WELWYN HATFIELD COUNCIL – DEVELOPMENT CONTROL
DELEGATED REPORT

APPLICATION No:	W6/2009/1633/EM
------------------------	------------------------

This application seeks Estate Management Consent for an extension to the existing rear outhouse. The extension would form part of the dwelling and the existing outhouse would be made habitable. The extension would extend the width of the outhouse by 1.59 metres and alterations would be made to the access from the side alley.

**189 Parkway  
Welwyn Garden City  
Proposed Extension**

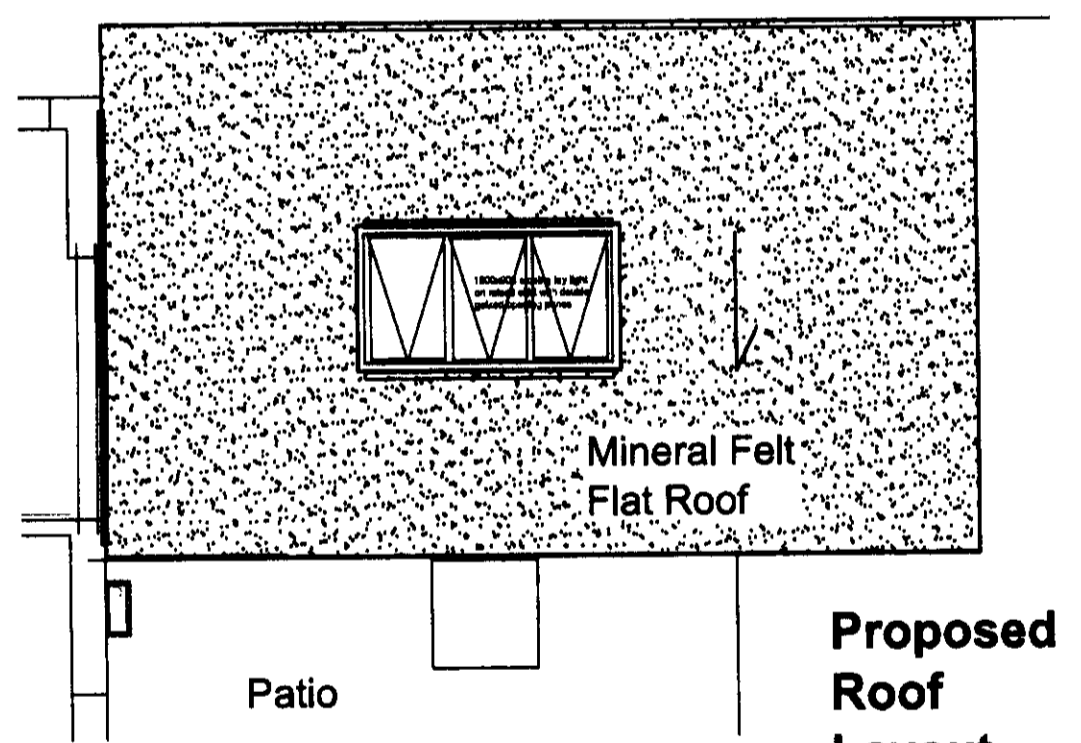
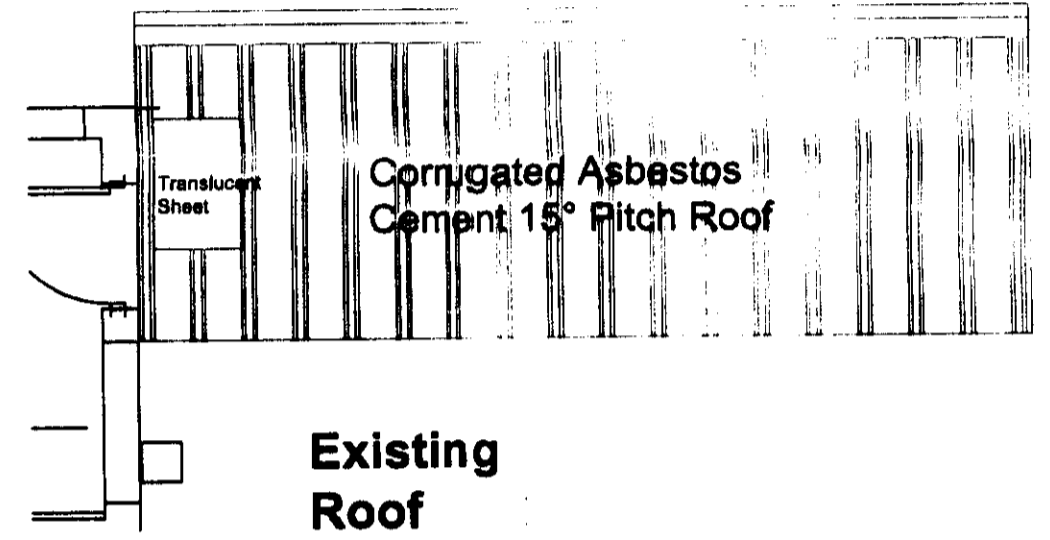
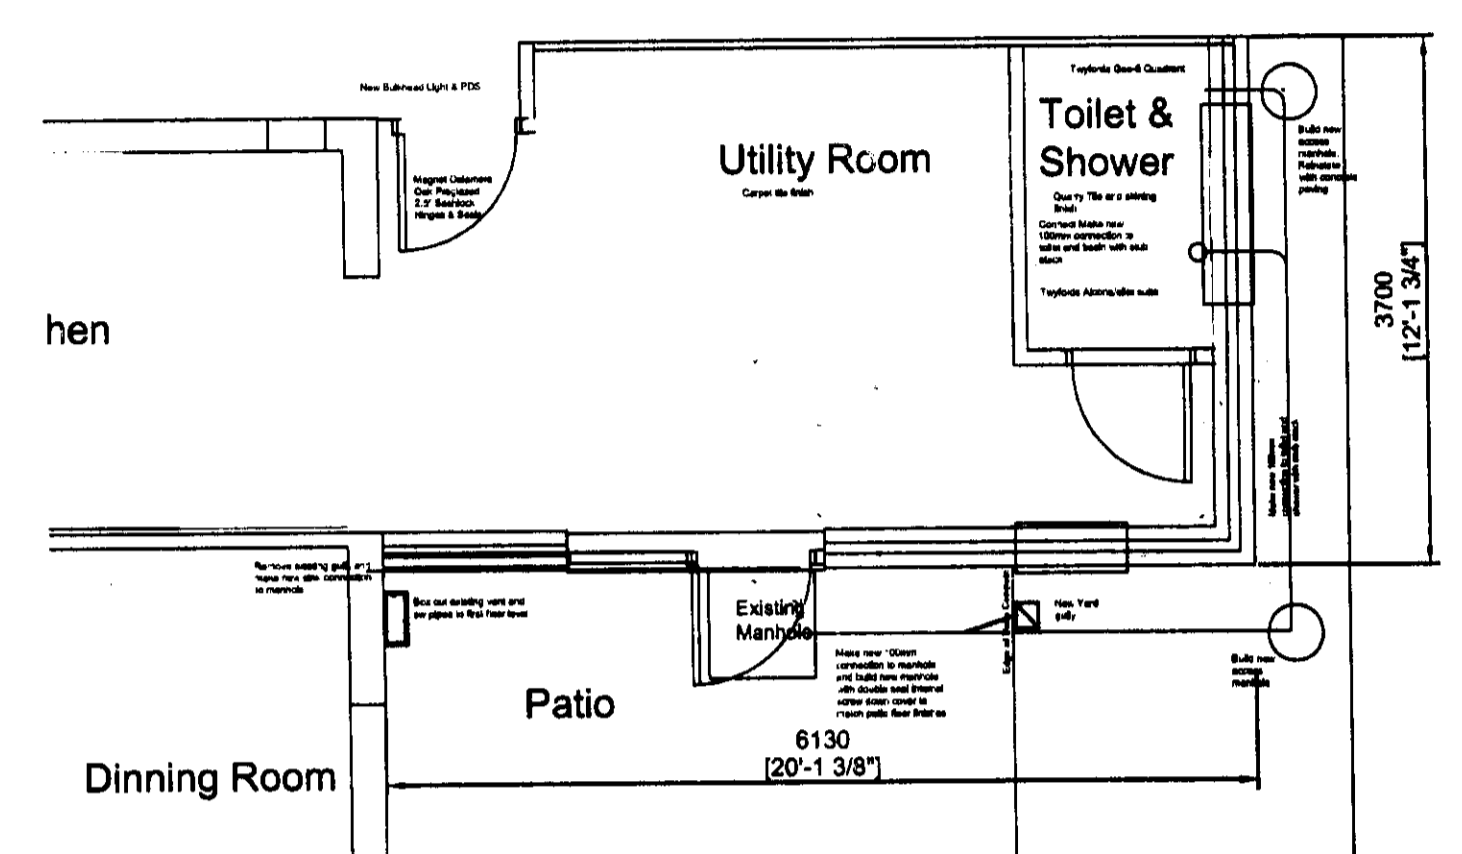
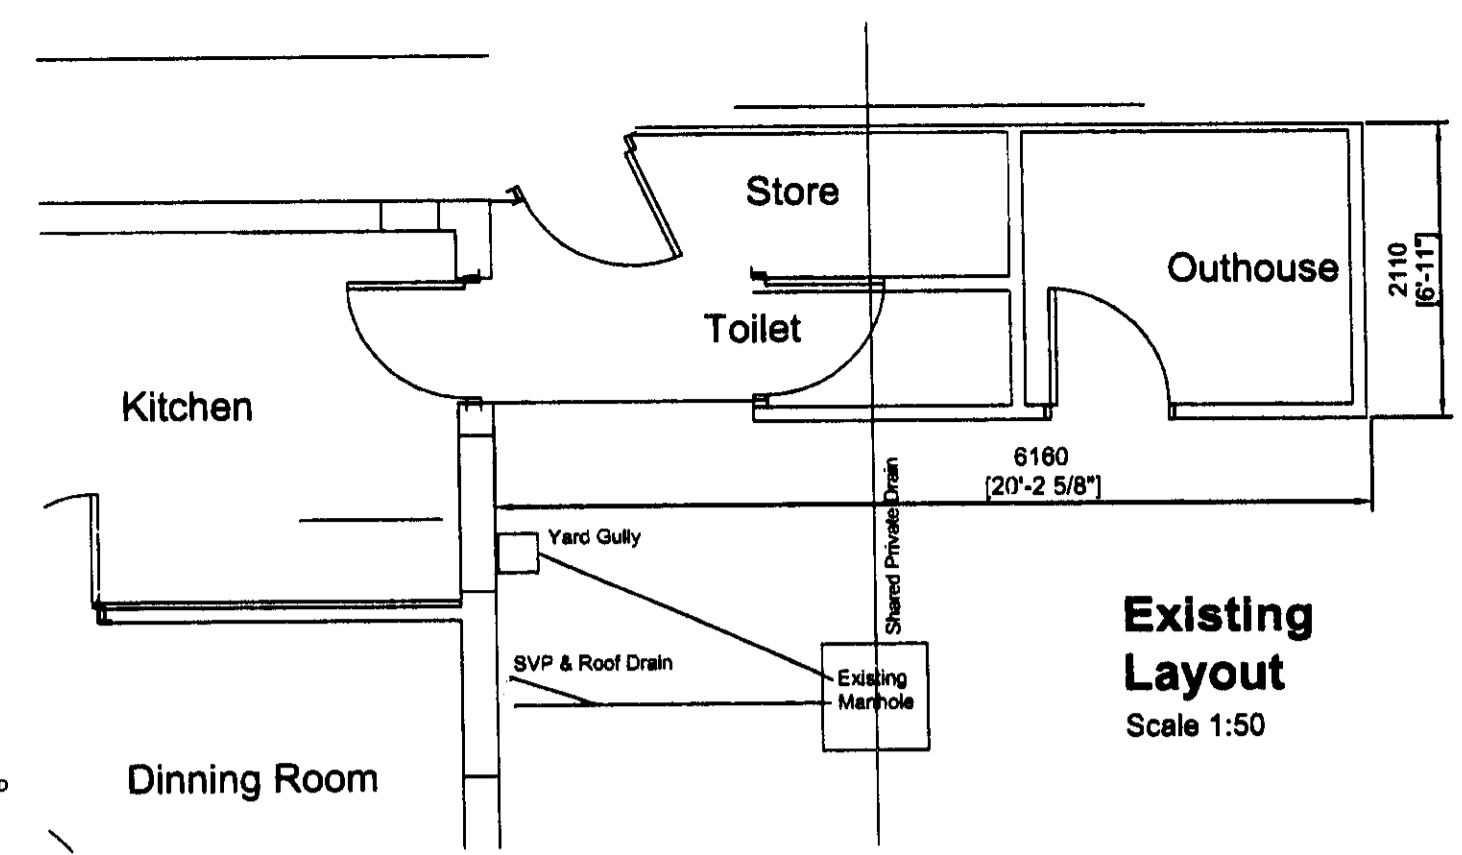
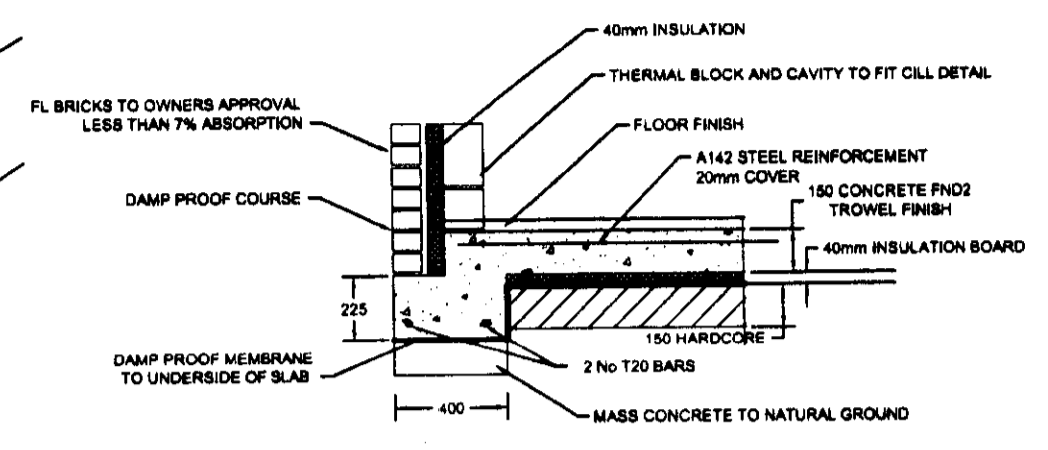
The general design and appearance of the extension would incorporate a flat roof which would be characteristic of the Garden City. The bricks that would be used would match the existing dwelling which would not detract from its general appearance. Whilst the window detailing of the extension would not match the existing detailing of the windows, it is considered that an appropriate condition could be attached to any consent which may be given, which would ensure that the windows were of a similar design and appearance to the existing dwelling. As such, it is considered that the proposed extension would not have an adverse impact on the character and appearance of the building and as a result would maintain the values and amenities of the Estate Management Area.

9. Notwithstanding the submitted plans, prior to development commencing a revised plan shall be submitted to and agreed in writing by the Local Planning Authority which revises the design of the windows to match the existing windows in the property.
